Date: 25 January 2018

Our ref: 14677/SSL/SW/15983452v1

Representations in relation to application for outline planning permission for up to 55 dwellings at East of Orchard Gardens Woodgate (ref. AL/129/18/OUT)

Appendix II: proposed site

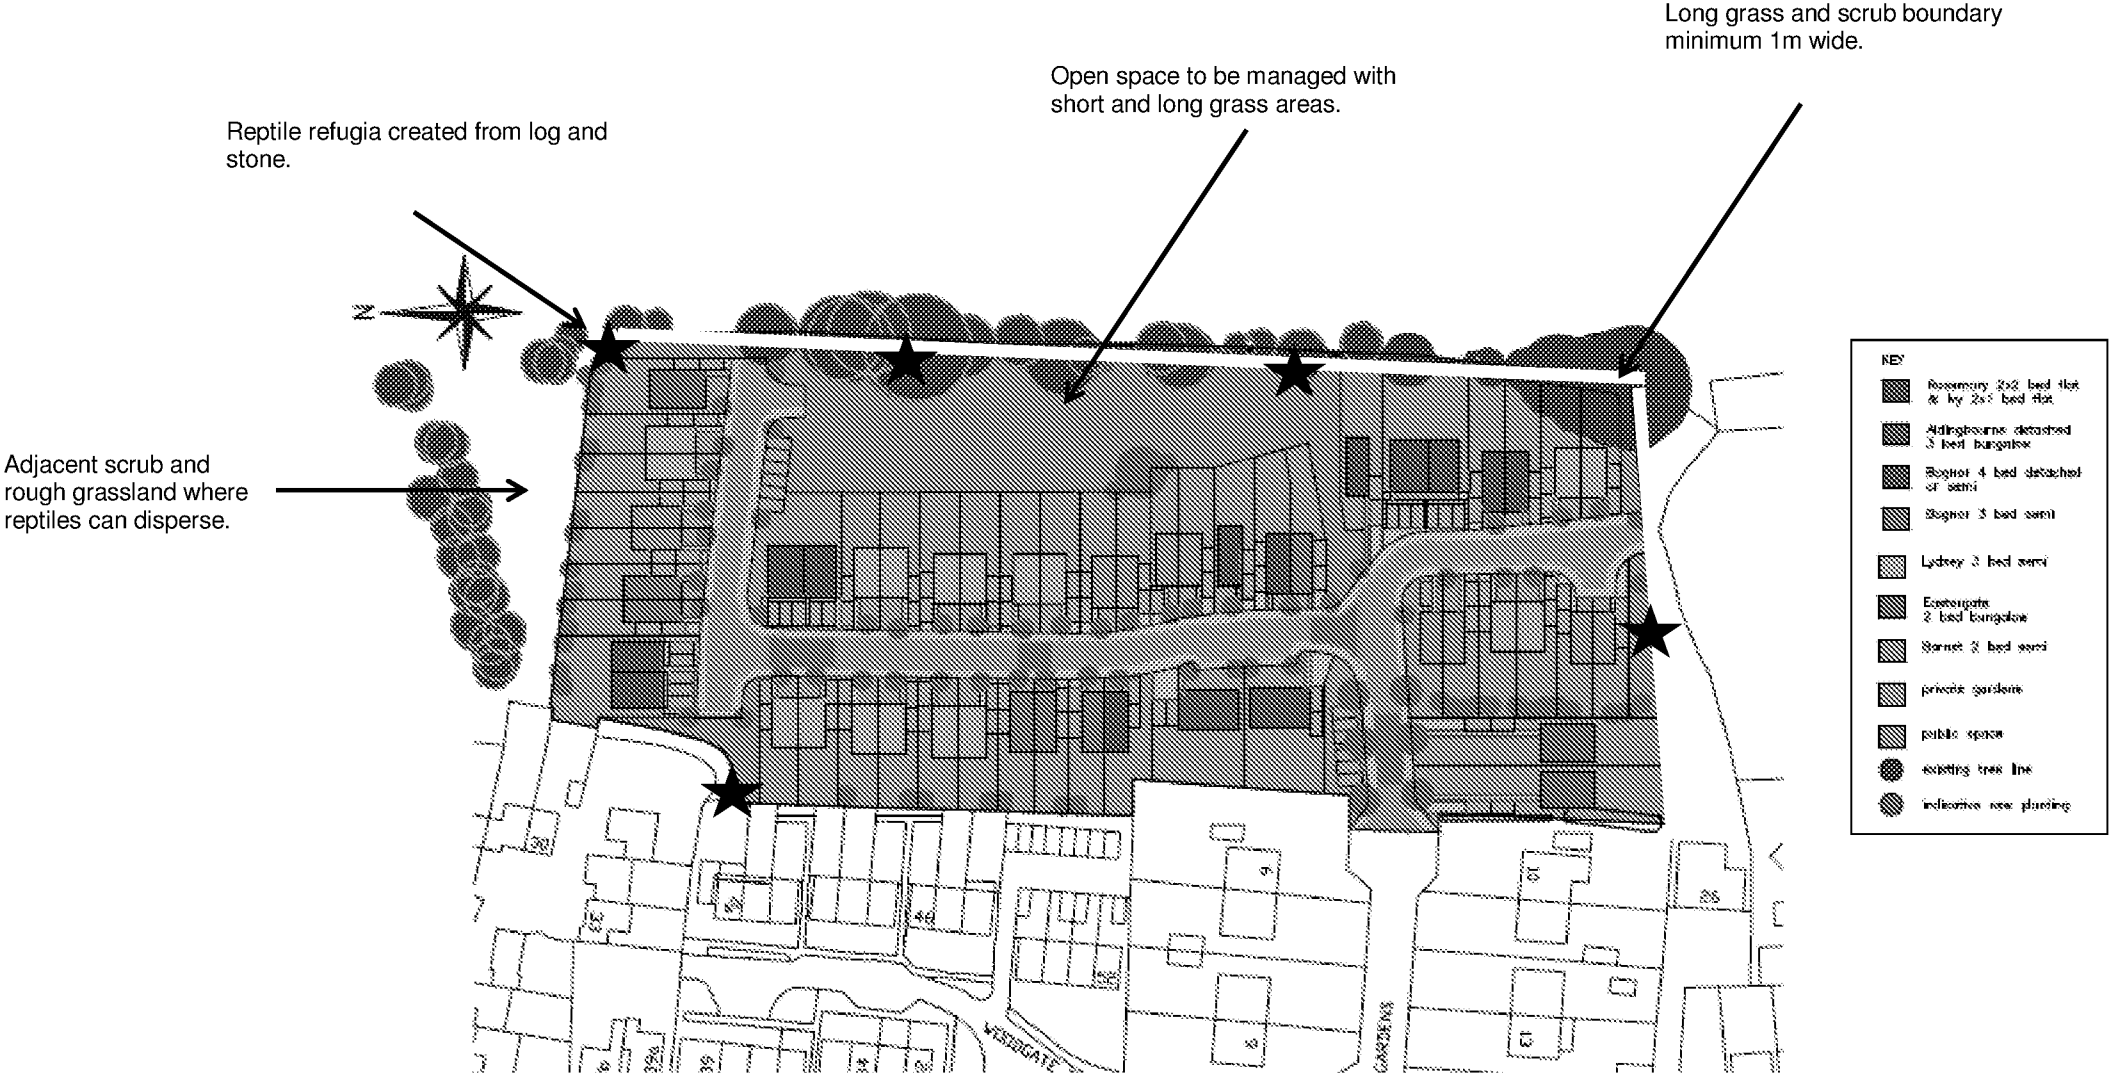
For this site specifically, connectivity with the proposed CALA site (ref. AL/15/17/PL) is important because it forms part of the wider BEW allocation and adjoins the site to the north and east. As a minimum, provision should be made for the internal roads to connect to the CALA site and to facilitate this, internal roads should continue to the site boundaries.

The proposed Site Layout (Site Plan 108/01 Rev D) does not successfully tie into the pedestrian and cycle connections in the wider area. It is important that these matters are considered prior to determination to ensure that the proposed development does not miss an opportunity to integrate with the wider BEW site at the appropriate time.
